CITY OF ALBUQUERQUE

RE: Chick-Fil-A @ Coors Pavilion – Additional Parking Lot
4001 Coors Blvd NW
Grading & Drainage Plan
Engineer's Stamp Date: 08/19/22
Hydrology File: G11D069C

Reference: Chick-fil-A #4107 Coors Albuquerque, NM
Hydrology File No.: G11D069C
IP # 2021.1239
Response to Conceptual Grading & Drainage Plan Review Comments

C-2.0

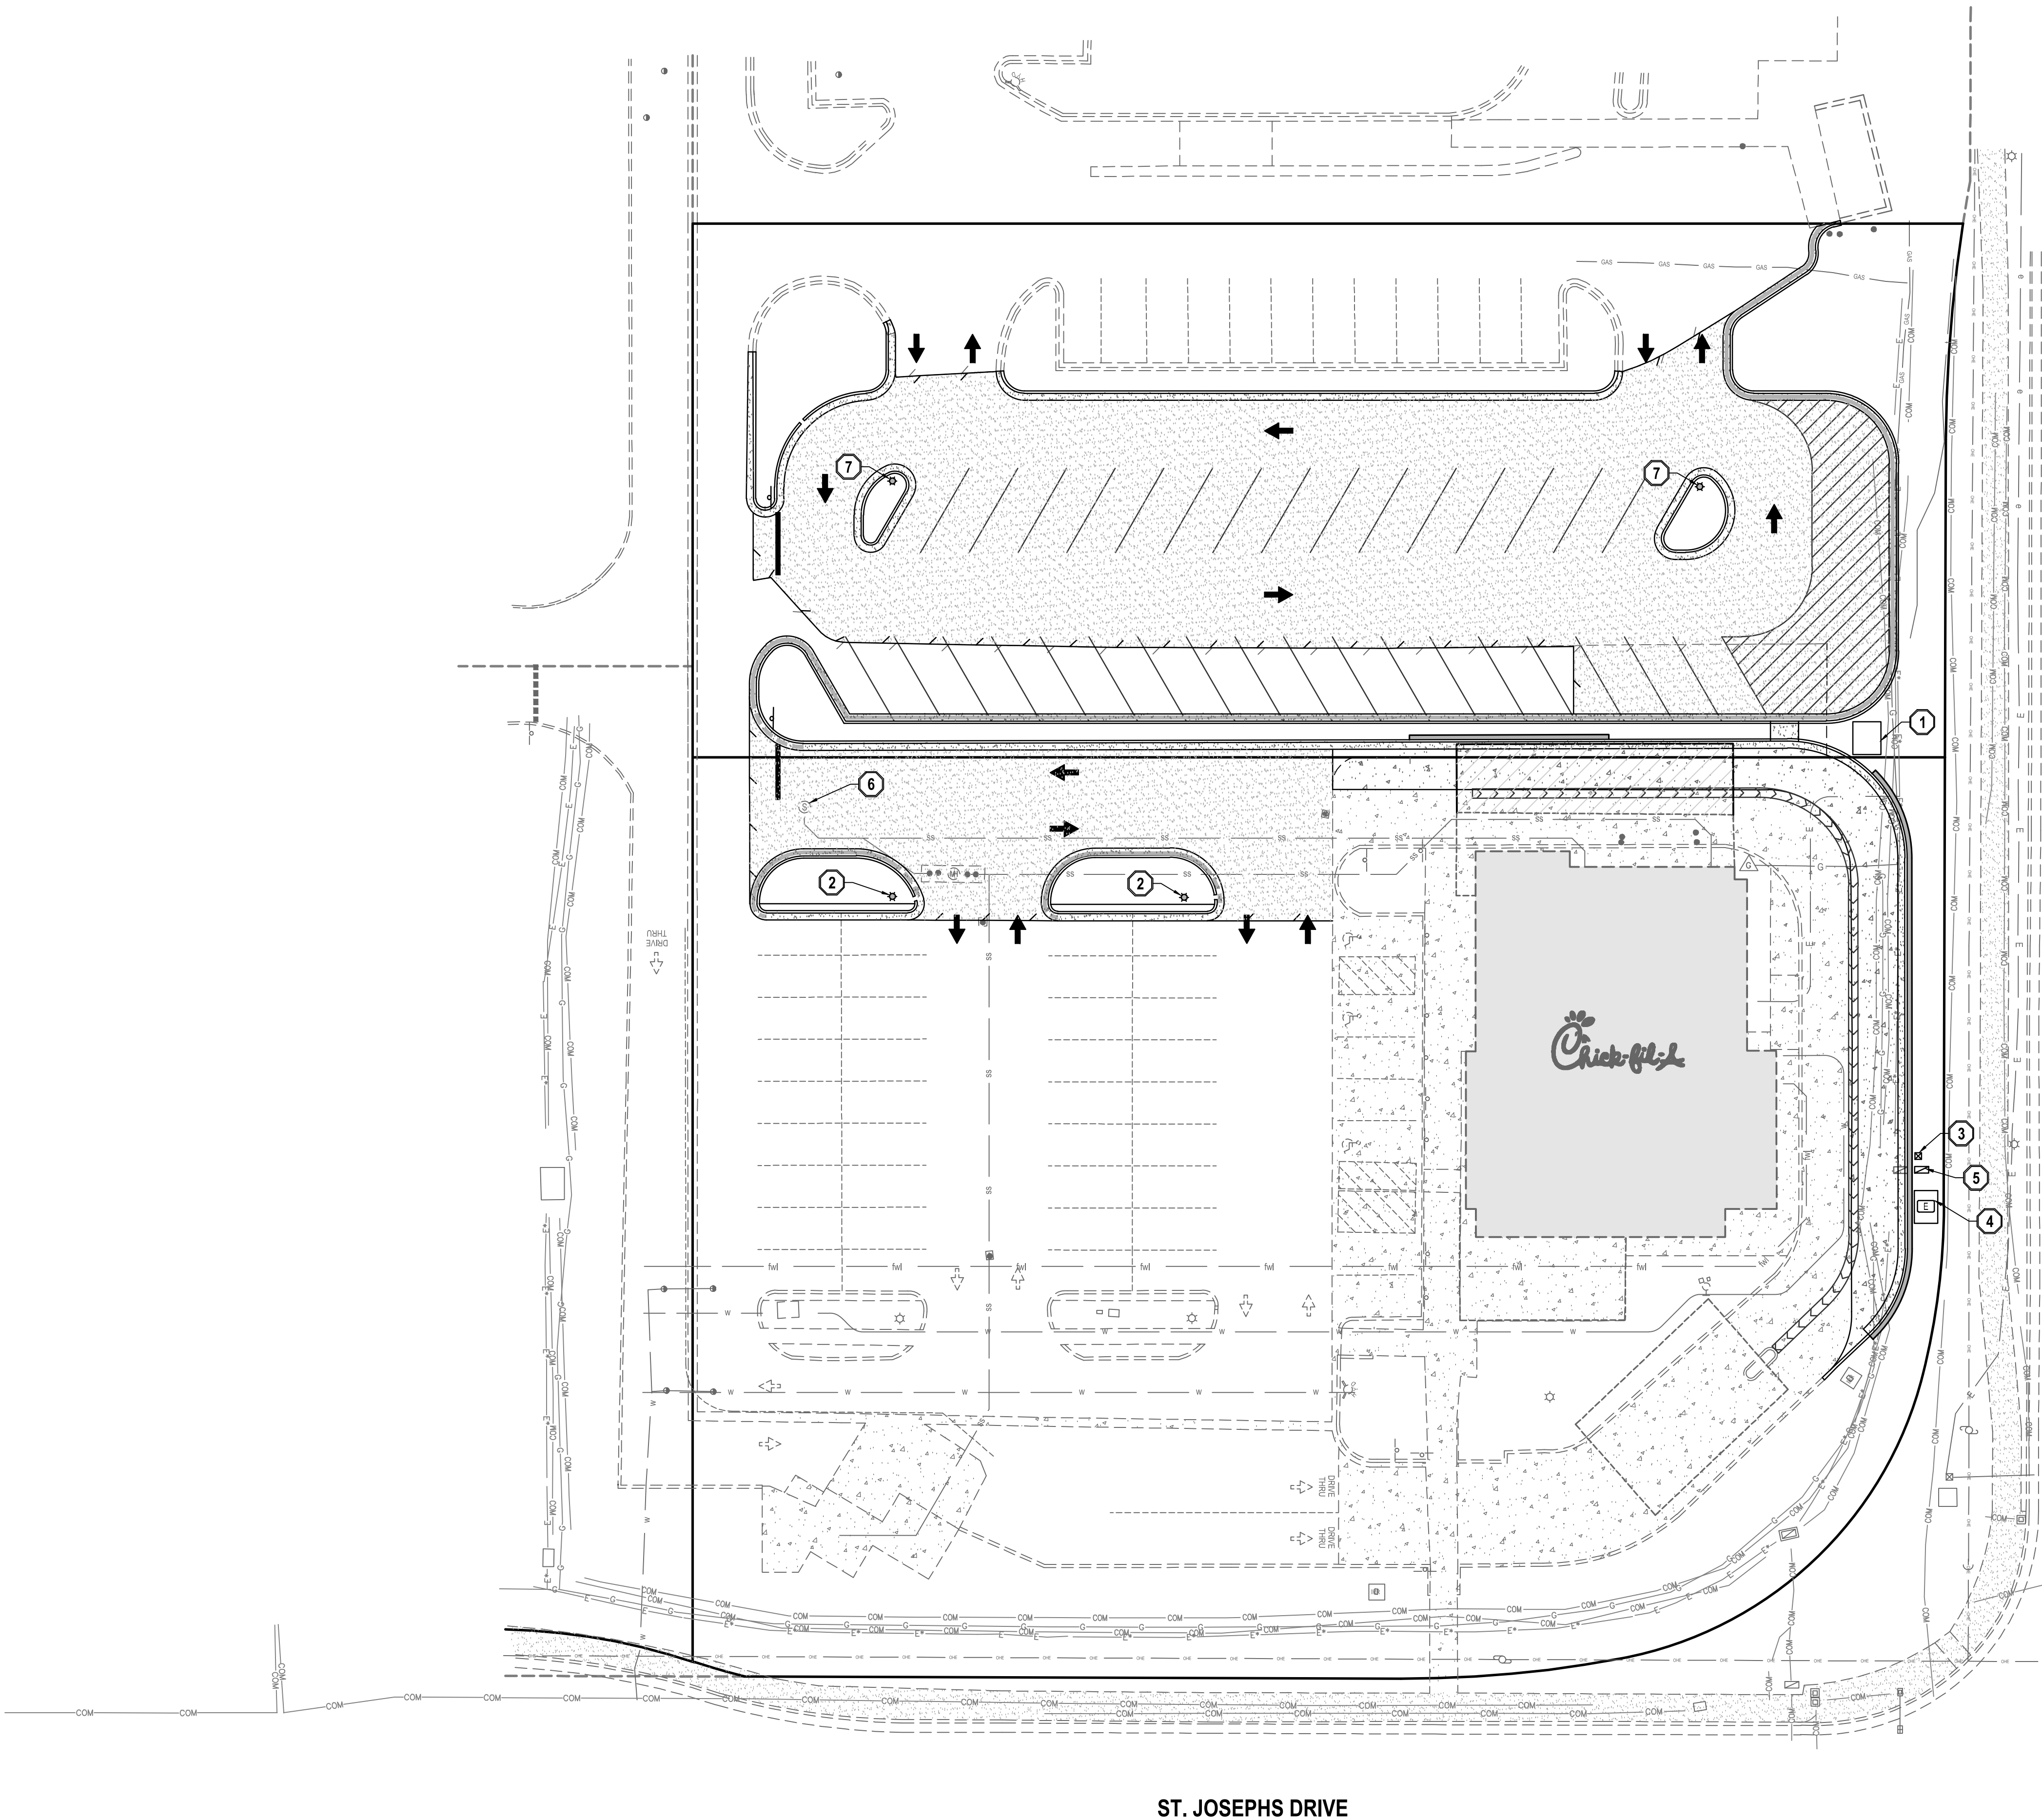
- 1. Comment:** Under Existing Conditions, please refer to the Amended Master Drainage Plan dated 12/2020 by Respec. Lot 5 (which the project is on) has a designed allowable discharge of 2.90 cfs which was designed to go directly north into Lot 4 but could be discharge into the private access / drainage easement which ultimately discharges into the Coors Pavilion detention pond.

Response: The procedure for a small basin outlined in the DPM was followed and sample calculations are shown in the Grading and Drainage plan.
- 3. Comment:** Please follow the DPM Article 6-12 Stormwater Quality and Low-Impact Development for the sizing calculations. To calculate the required SWQV, multiply the impervious area draining to the BMP by 0.42 inches for new development sites.

Response: The SWQV was calculated per section 6-12 and calculations are shown in the grading and drainage plan.
- 4. Comment:** Please provide the SWQV calculations for each basin draining to each pond. The stormwater quality ponds need to be sized for the areas draining to them.

5. **Comment:** Please label the size of each curb cut and please provide the weir calculations, per DPM Article 6-16(A), for the curb cuts. A coefficient of 2.7 is typically used for the weir equation $Q = CLH^{2/3}$.

6. **Comment:** Not sure where the drainage from Basin 2 (the new drive lane) is going. This drainage cannot go directly into Coors Blvd. This is not allowed. I do not see how this is directed towards the interior private access / drainage easement.

Response: The Amended Master Drainage Plan dated 12/2020 was used as a reference when designing the conceptual grading and drainage plan.
- 2. Comment:** Please use the procedure for 40 acre and smaller basins as outlined in Development Process Manual (DPM) Article 6-2(a). Please provide both the existing conditions and proposed conditions for the 100 year-6-hour storm event. Please show the calculations per the DPM and not just the end result.

Response: Calculations are shown in the grading and drainage plan

Response: Curb cut opening size is called in the site plan and calculations are shown in the grading and drainage plan.

Response: There is a proposed infiltration trench to prevent drainage from running directly into Coors Blvd. Calculations are shown in the grading and drainage plan.
